DECISION DELEGATED TO HEAD OF PLANNING

Application No: H14-0219-25 **Applicant:** Ms Y Liu

Proposal: Demolition of single storey rear extension & erection of single storey rear extension & alterations

Location: Whitebeams 1 Money Bridge Lane West Pinchbeck

Drawing Number:
A1770-01
Rev:
P2

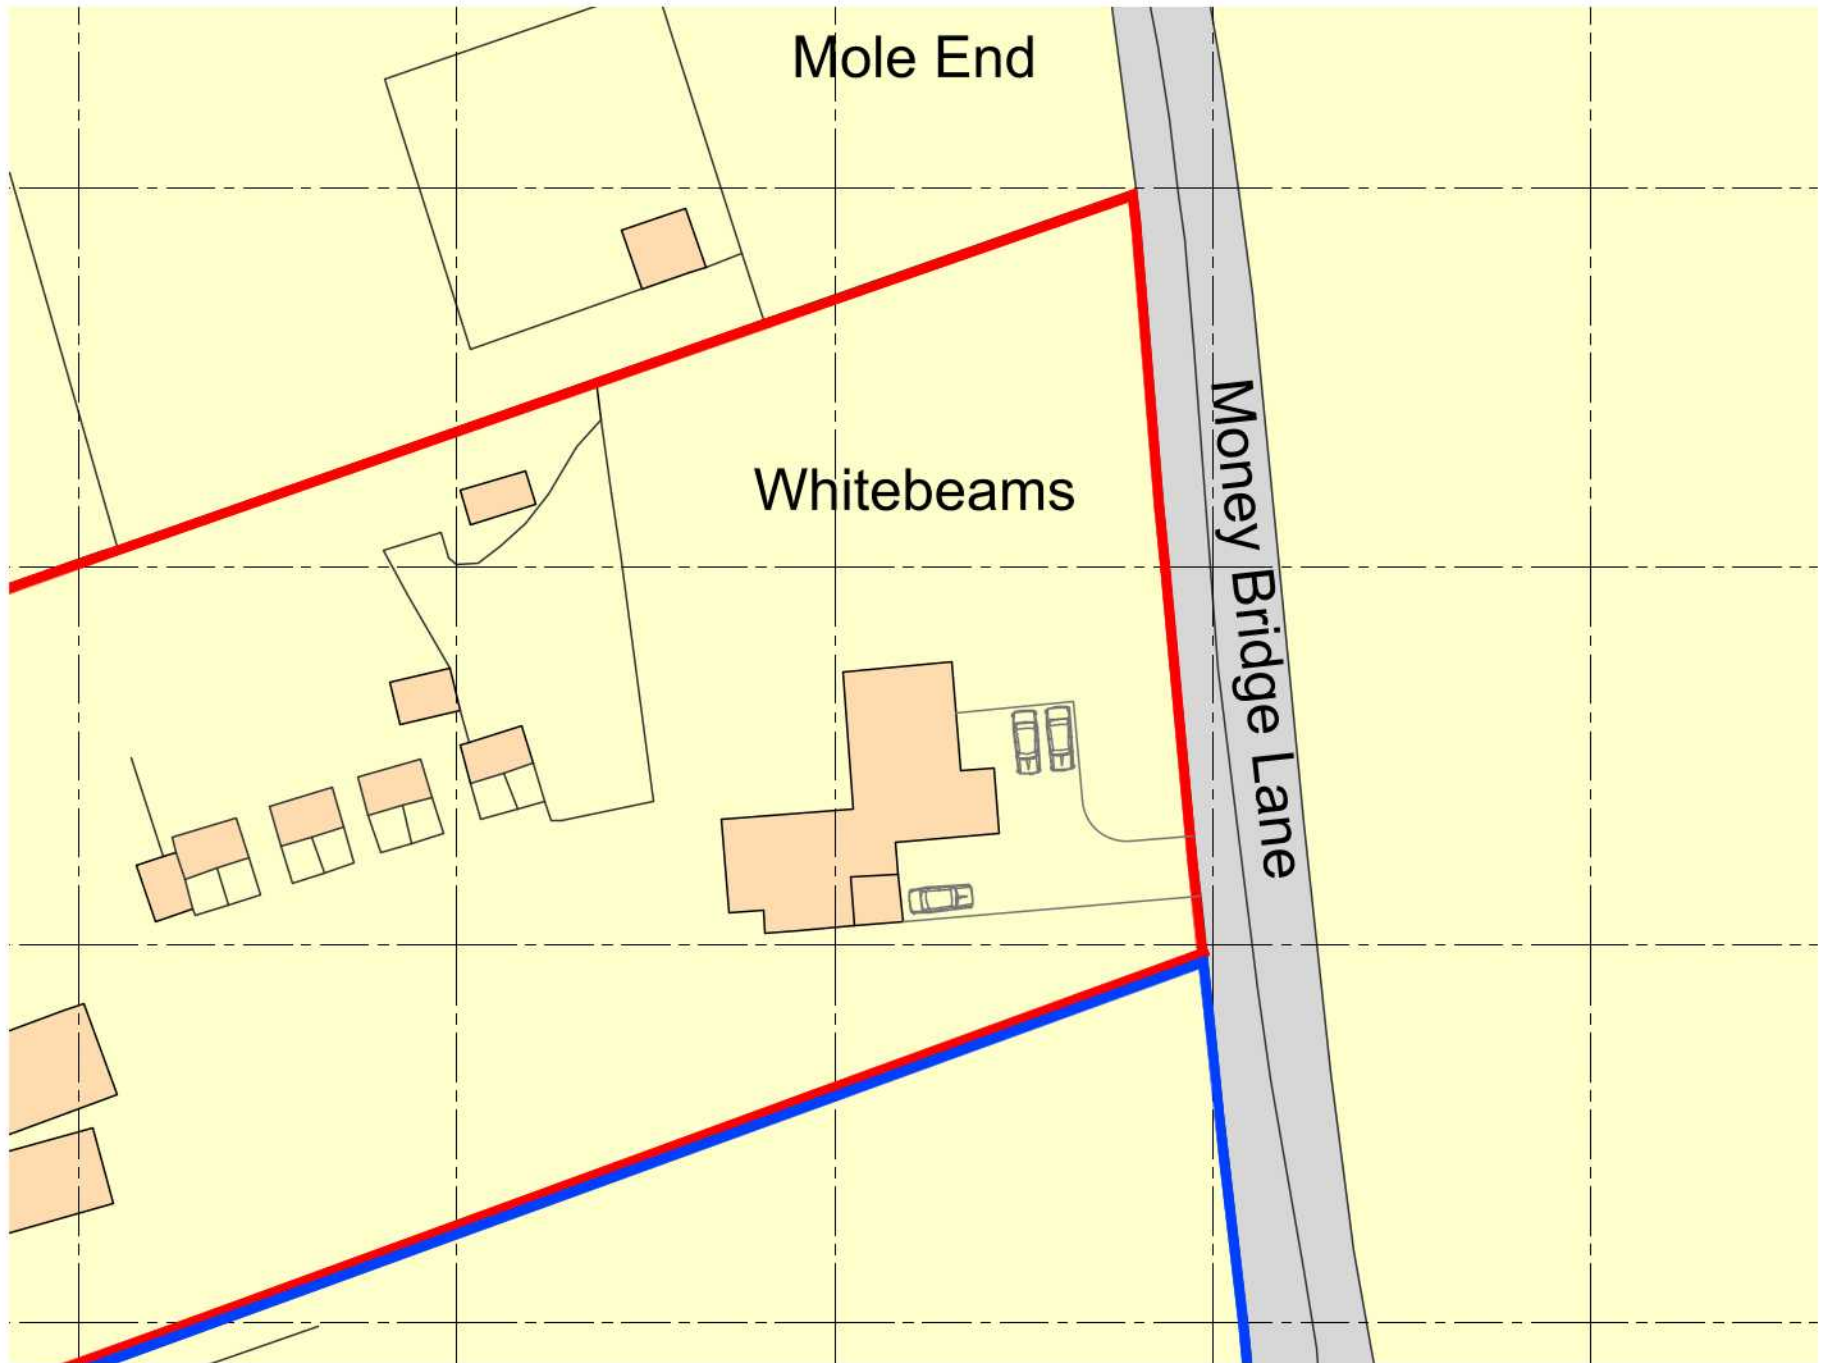
Lincolnshire County Council - Highways and SUDS: The parking and turning should be detailed on the block plan.

Lincolnshire County Council's highways team have requested that the parking arrangements and turning area should be set out on the proposed site plan. The proposed extension would not alter the parking requirements for the site and there is sufficient room for parking within the front driveway of the site. This is demonstrated within an updated version of the site plan that has been submitted for clarity.

The red line boundary has also been reduced during the determination of the application to exclude the southern part of the site. The amended red line boundary is considered to be more suitable as a likely area for the residential curtilage of the dwelling.

Drawing Title:
Plans, sections and elevations as proposed

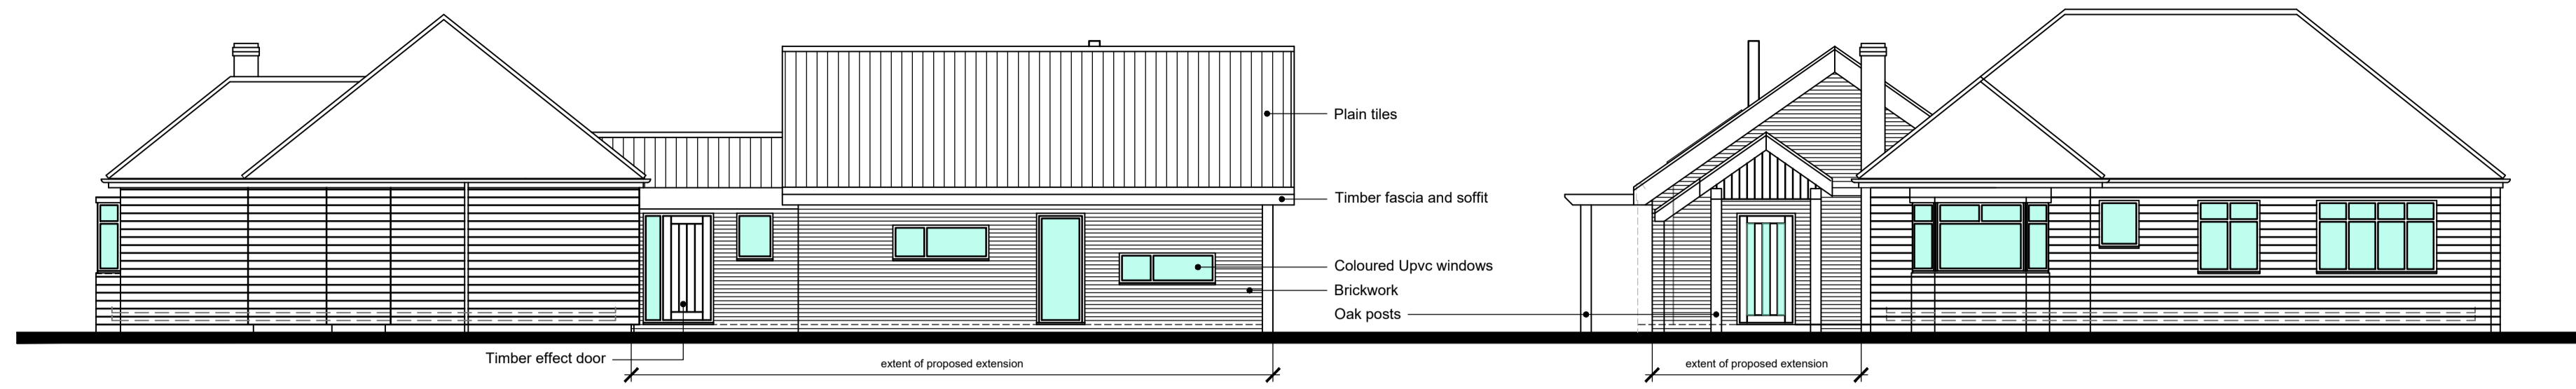
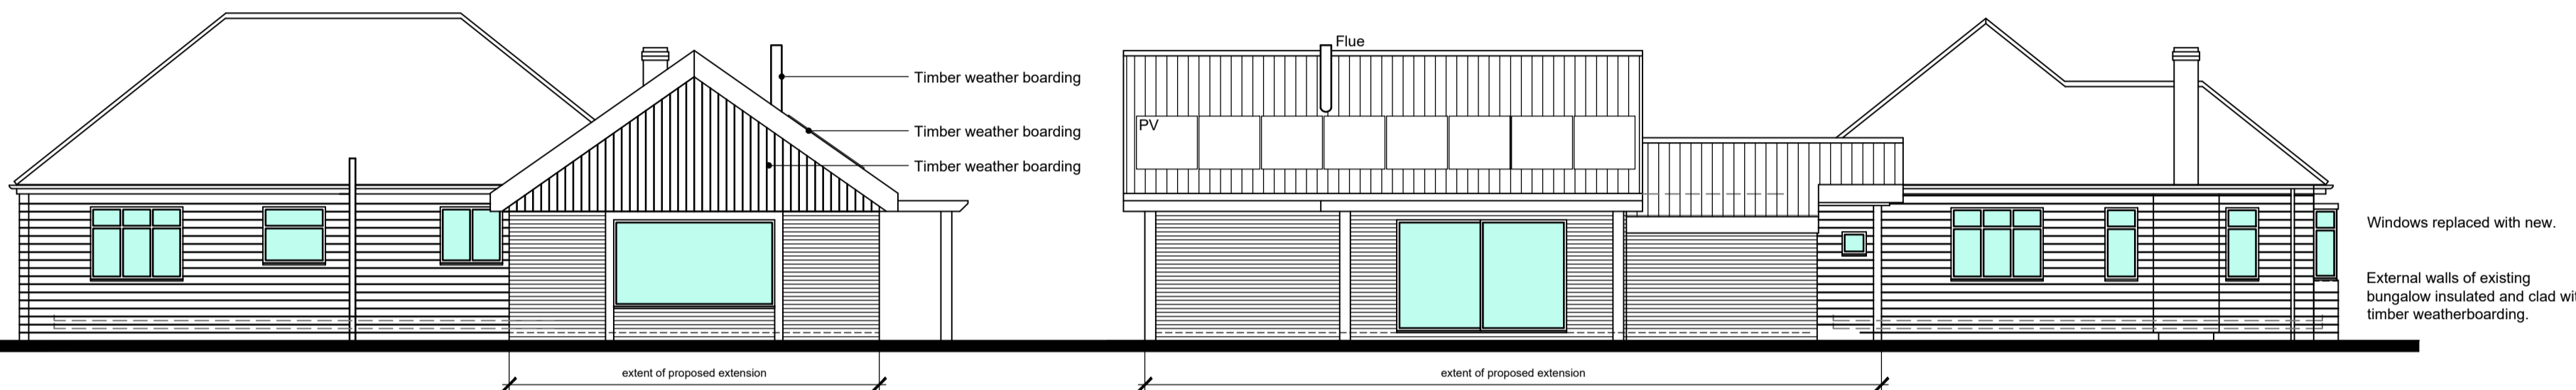
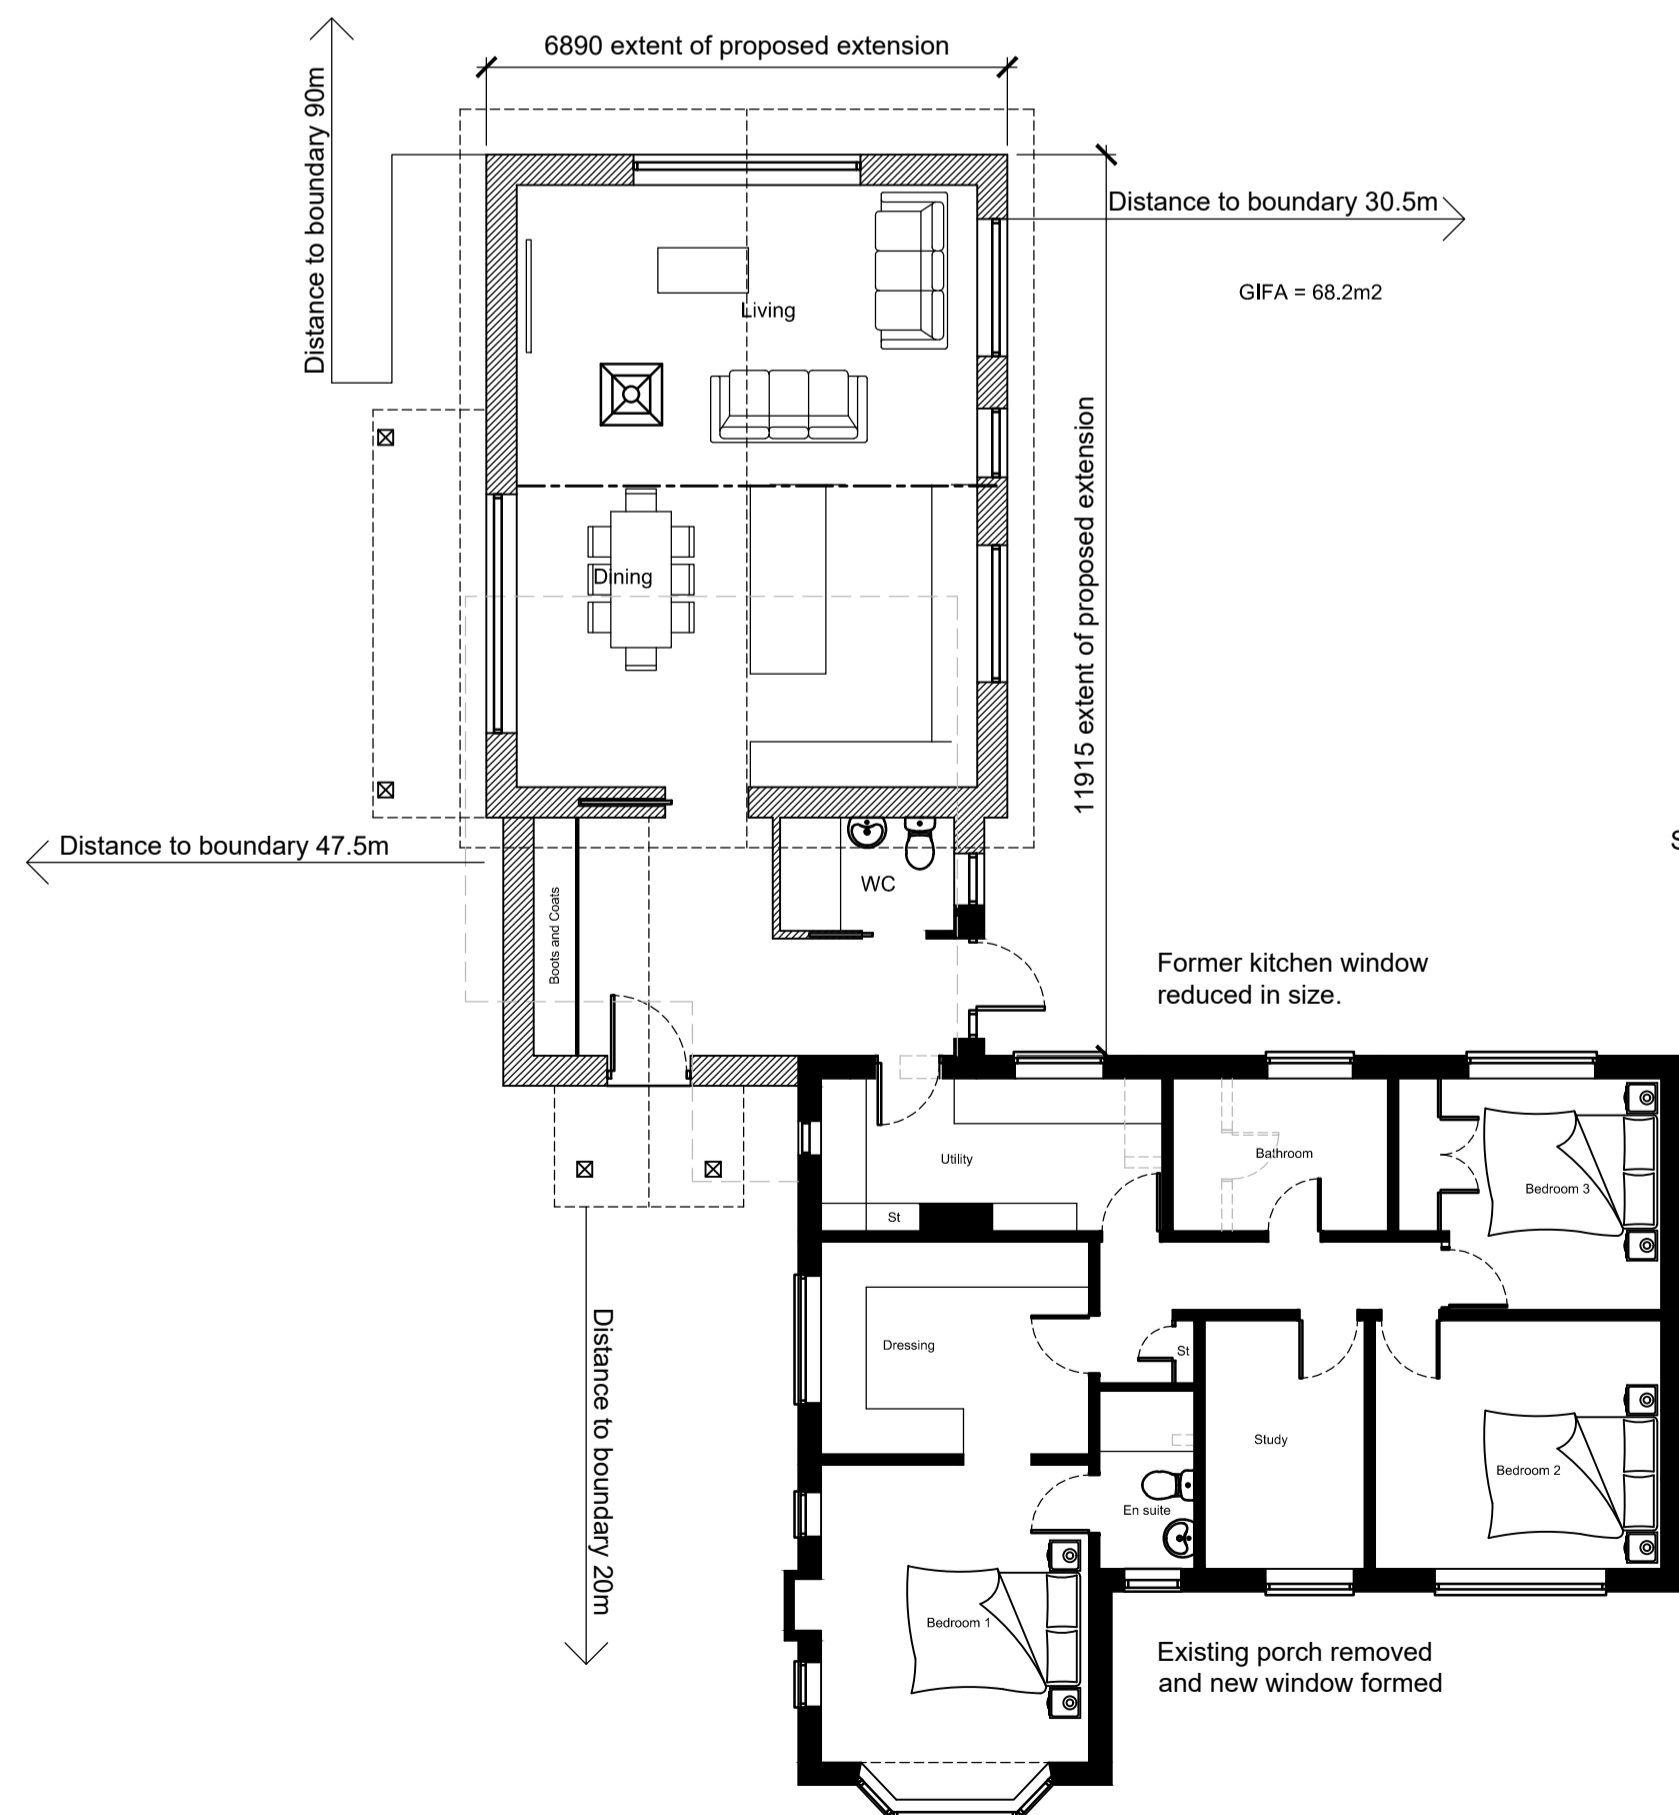
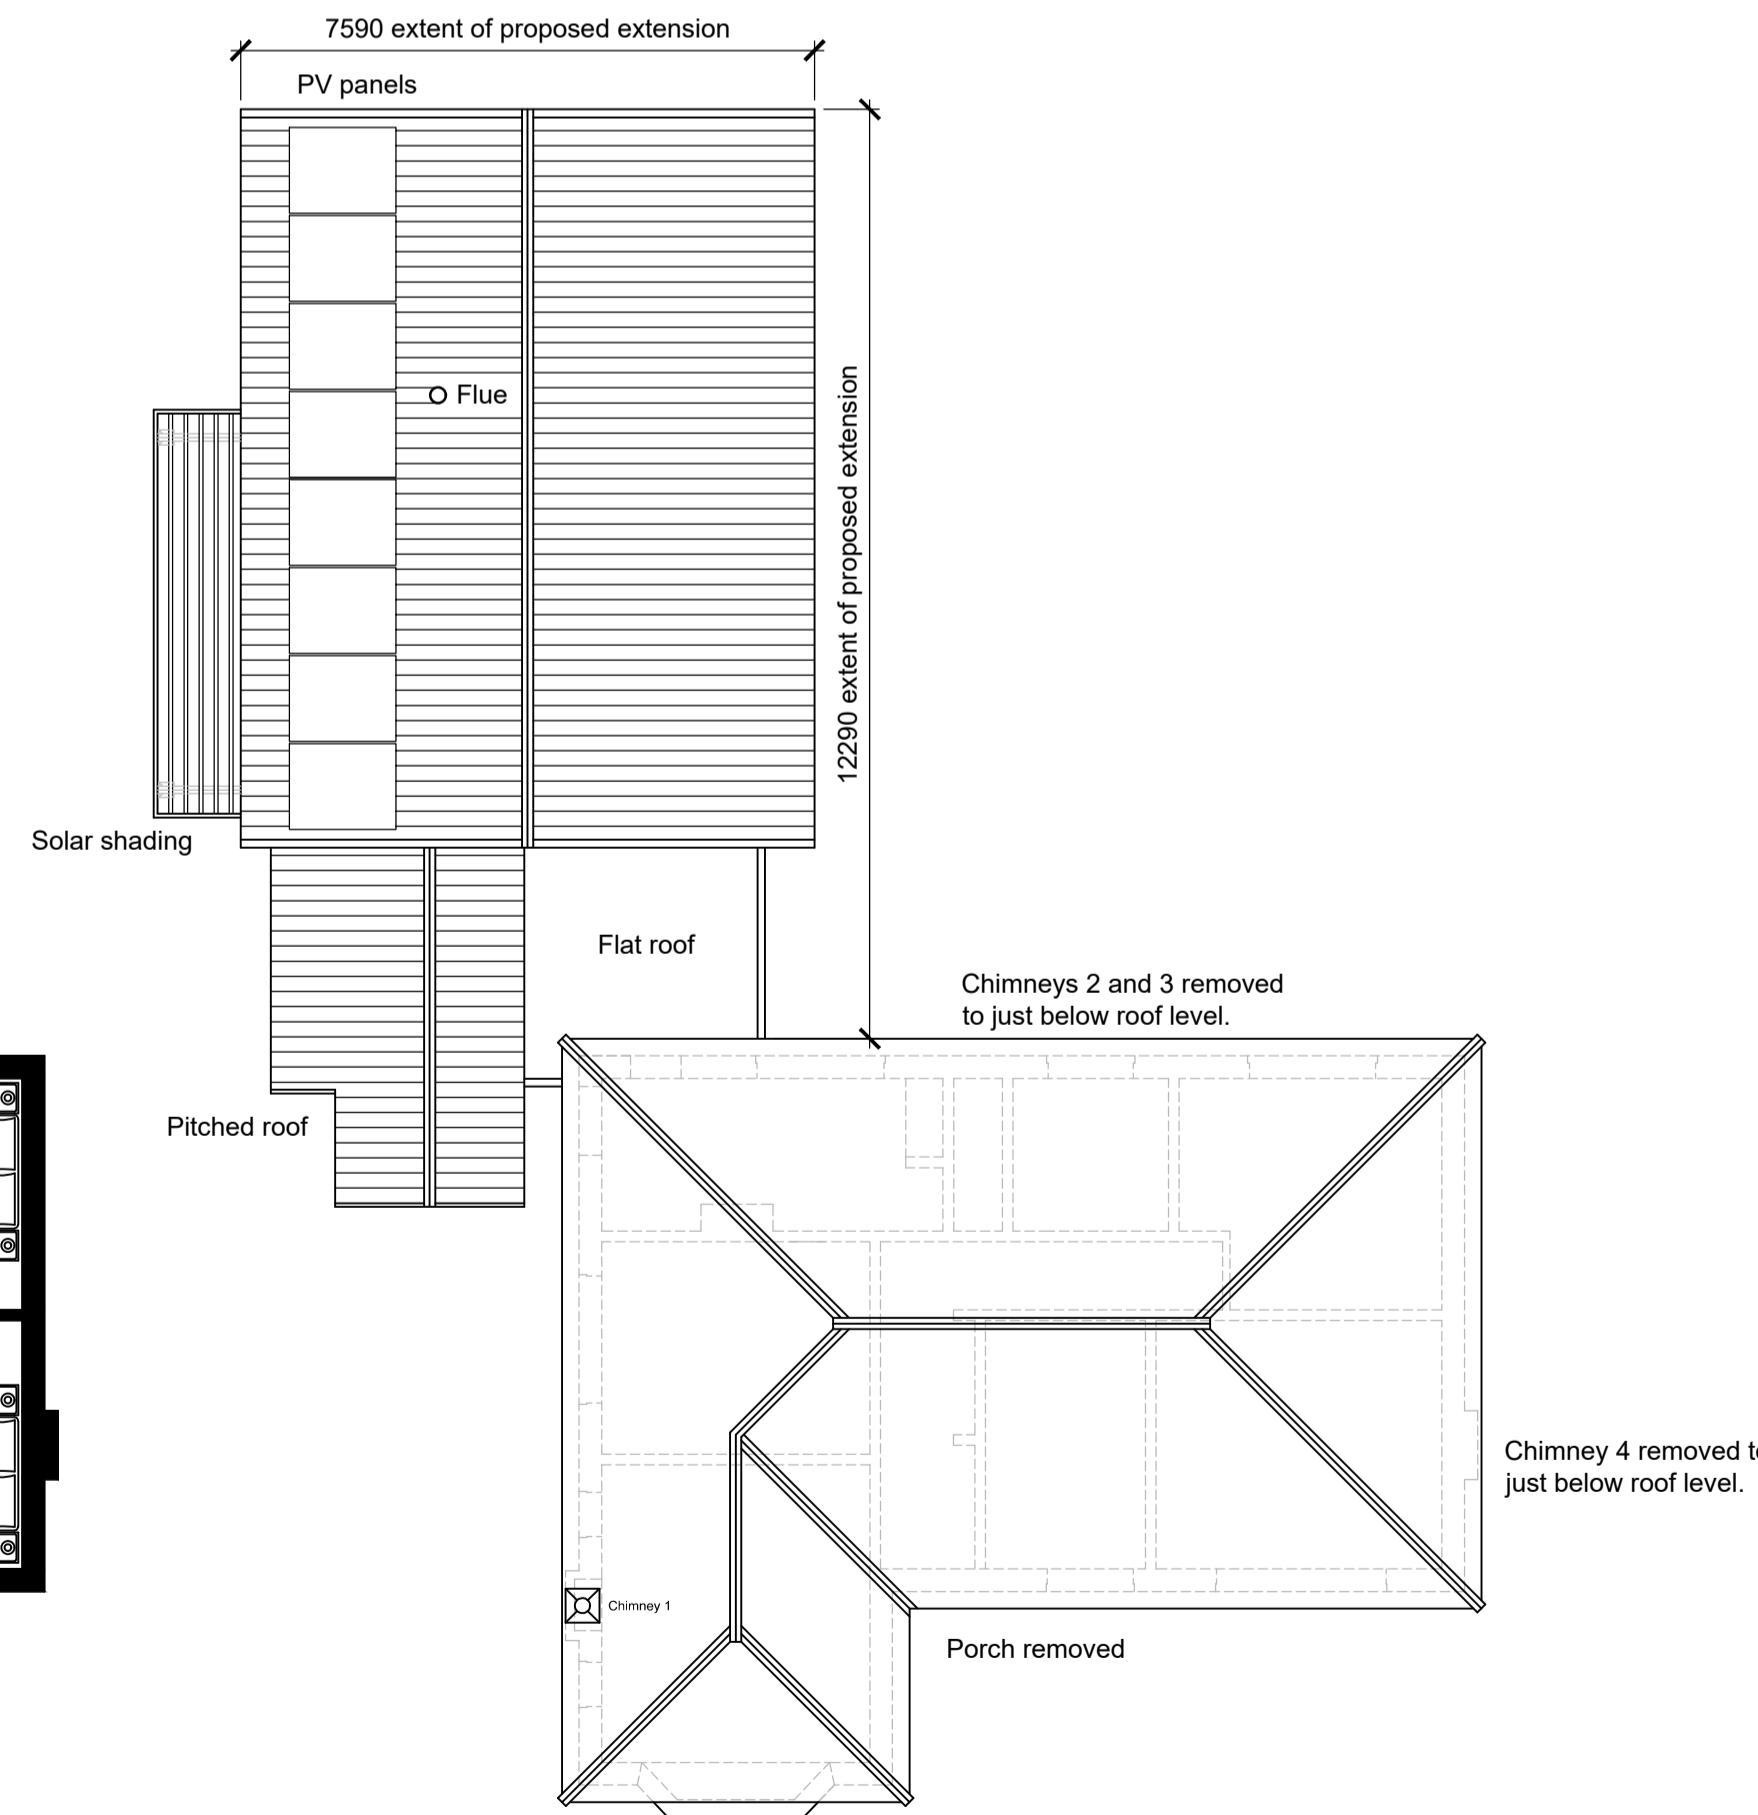
The submitted plans indicate that the external walls of the existing bungalow are proposed to be clad with timber weatherboarding. The dwelling currently features red brickwork. The proposed extension is proposed to feature 'brickwork'. The proposed colour and brick type are not indicated. Similarly, the proposed roof tiles are merely set out as 'plain tiles'. The contrast of weatherboarding on the main dwelling and brickwork on the extension might be acceptable as the two materials can complement one another. Furthermore, the proposed extension is set back towards the rear of the dwelling, reducing its visual prominence within the street scene. It is however considered necessary to secure further details of the proposed materials through a condition in order to ensure that the proposed materials are of a suitable quality and appearance.
